WEST SUSSEX COUNTY COUNCIL CONSULTATION

TO:	Arun District Council FAO: Andrew Wood
FROM:	WSCC - Highways Authority
DATE:	28 March 2019
LOCATION:	Fairmead Farm Land Binsted Lane Arundel BN18 0LQ
SUBJECT:	WA/23/19/DOC Approval of details reserved by condition imposed under ref WA/84/17/PL relating to Condition Nos 4 vehicular access and 6 external lighting.
DATE OF SITE VISIT:	n/a
RECOMMENDATION:	Advice
S106 CONTRIBUTION TOTAL:	£ n/a

SWEPT PATH ANALYSIS USING A
PICKUP TRUCK + TRAILER

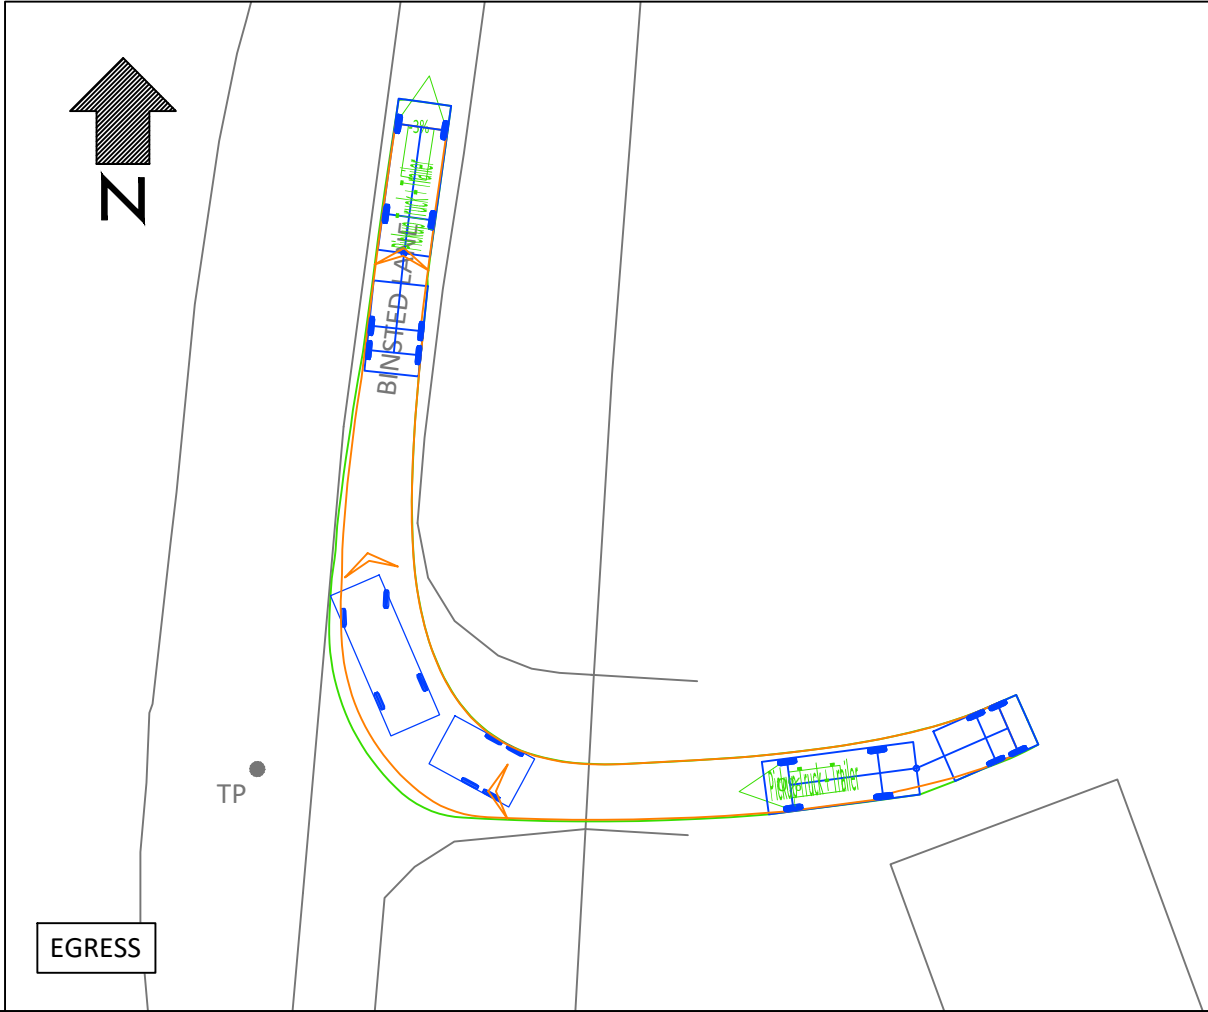
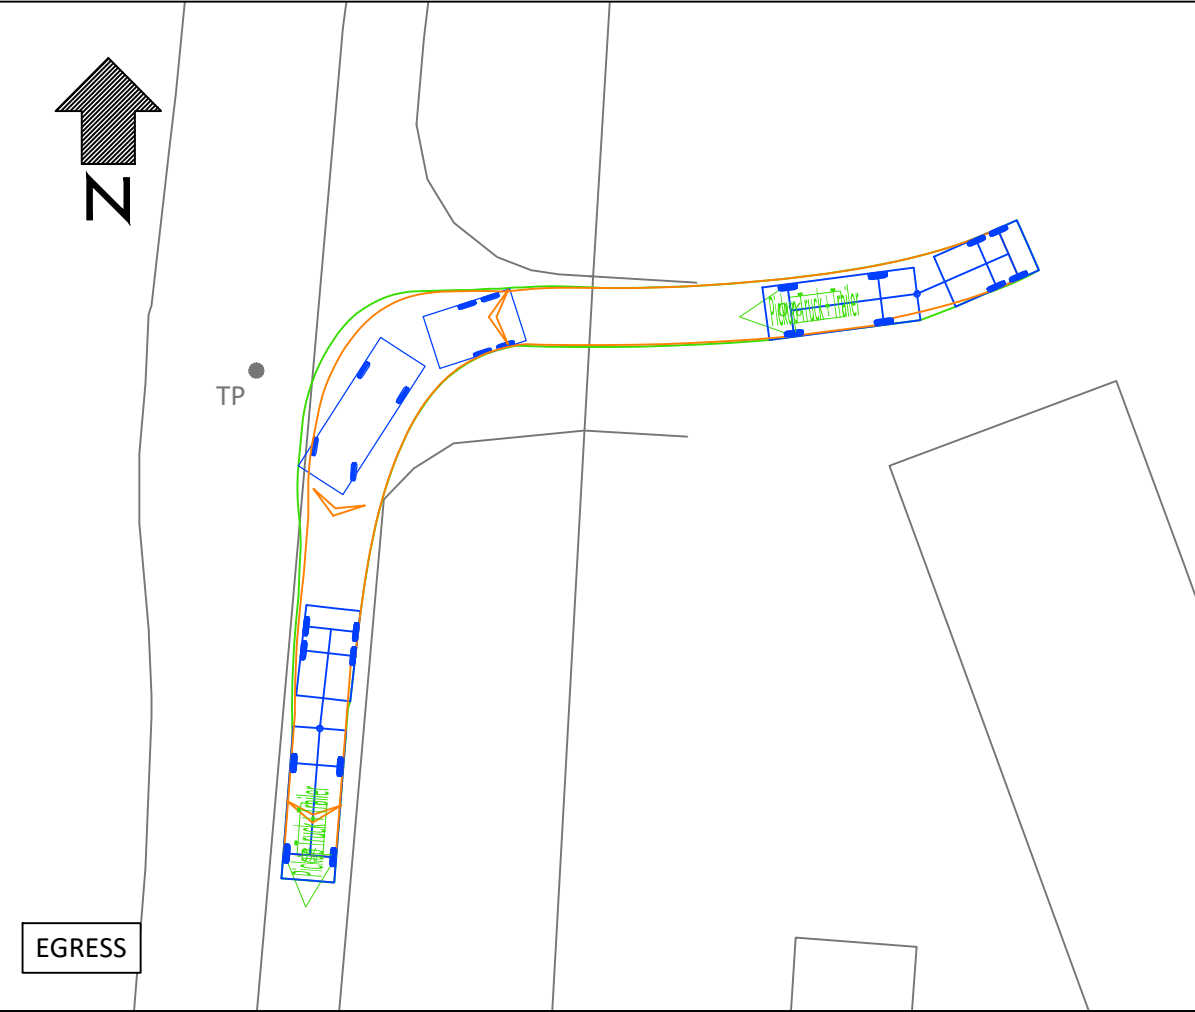
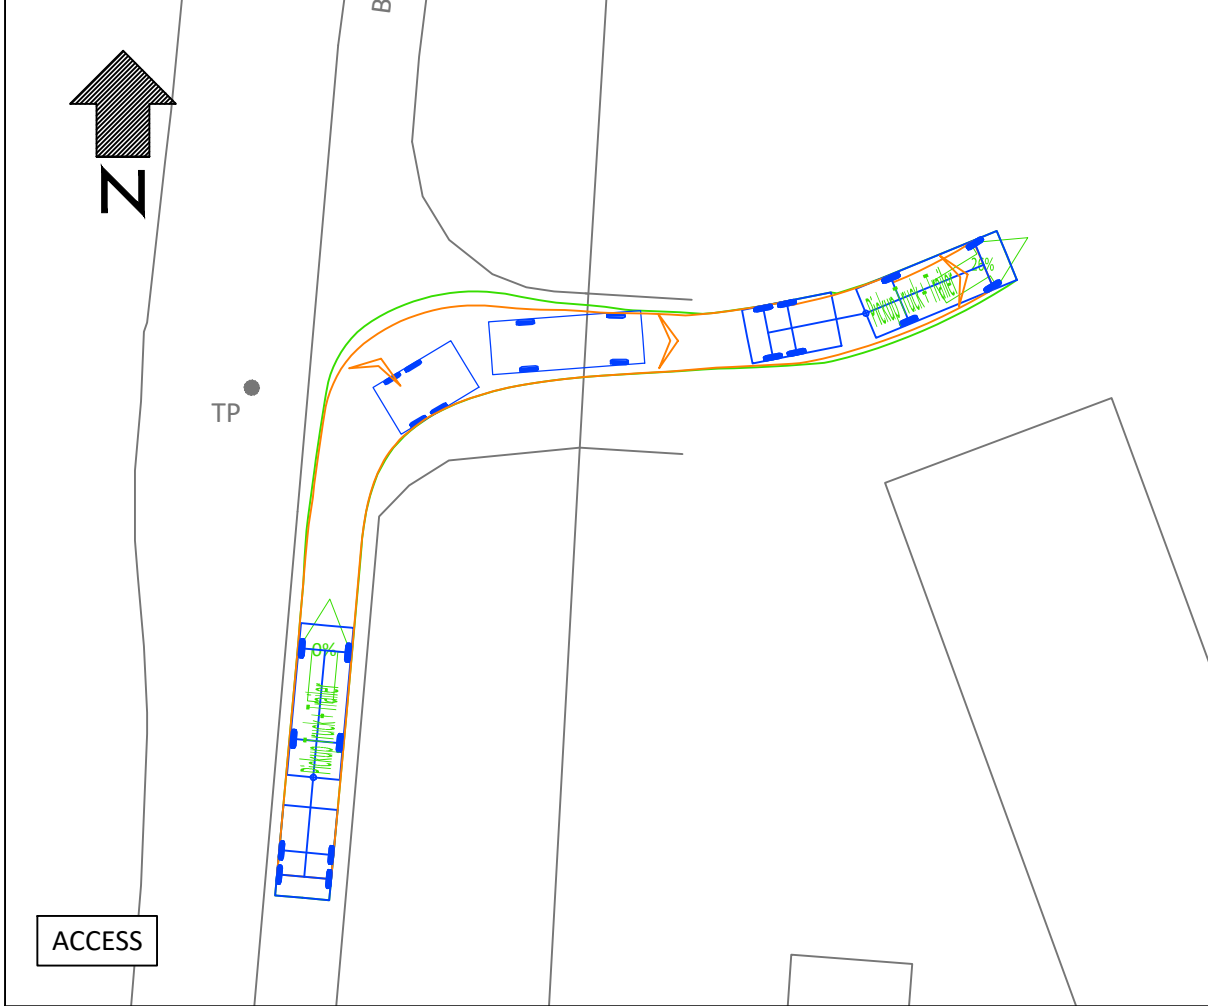
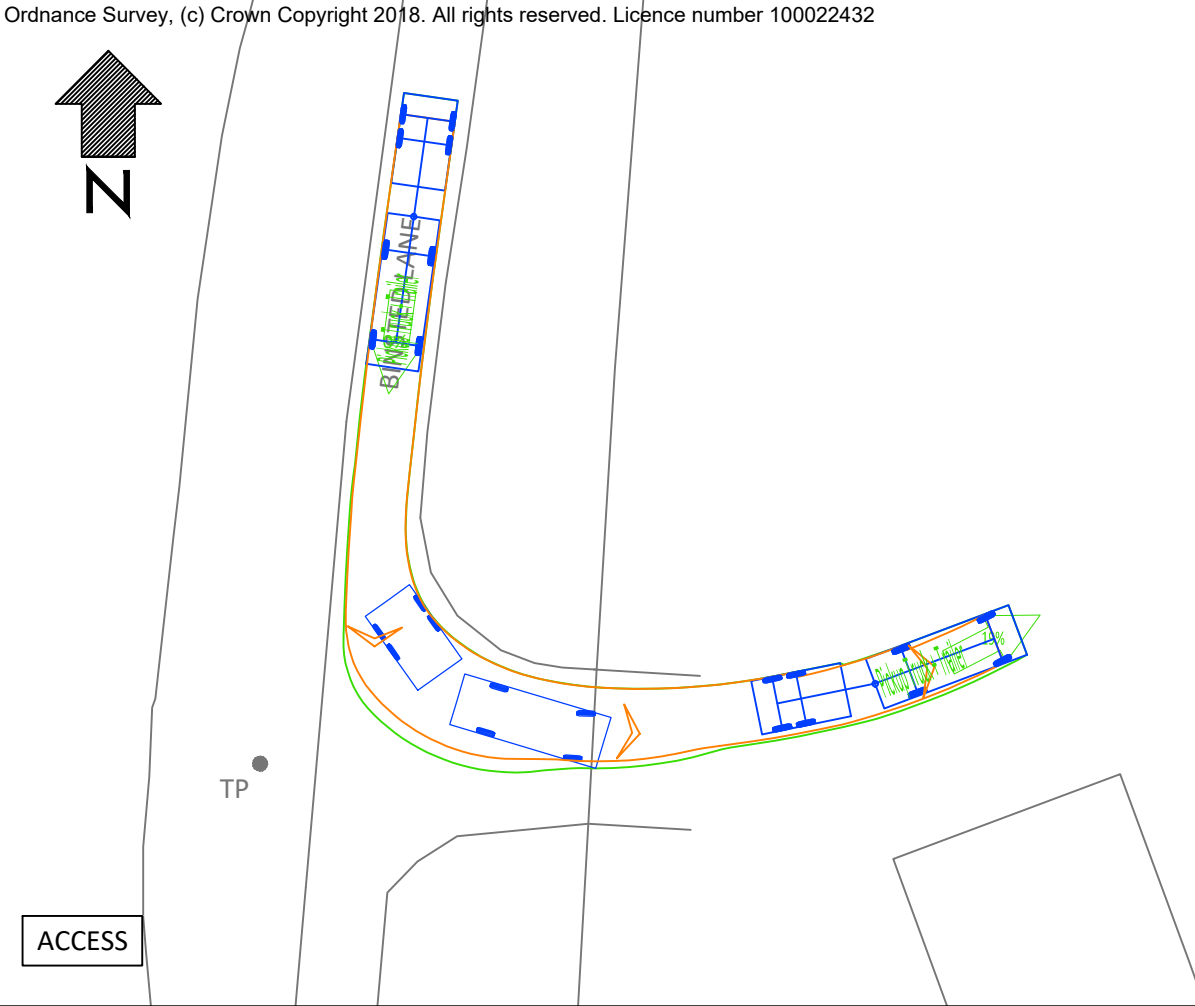
After inspection of the newly submitted plans covering Condition Nos. 4 - Vehicular Access, the Local Highways Authority (LHA) would comment that these are acceptable.

The access is constructed from loose material. This may result in material being dispersed onto the public highway affecting the surface of the road. The applicant should provide a gravel trap or area of block paving, or other bound material, at the point of access onto Binstead Lane (on land within the applicant's control; not within the publicly maintained highway).

However the LHA are mindful that there is an access existing here and an existing use within the site which could already result in material being pulled onto the carriageway. As such continuing with this existing surfacing arrangement can be considered acceptable in principle. The LHA would advise that it is the responsibility of the applicant to rectify any issue of debris in the highway at their own cost.
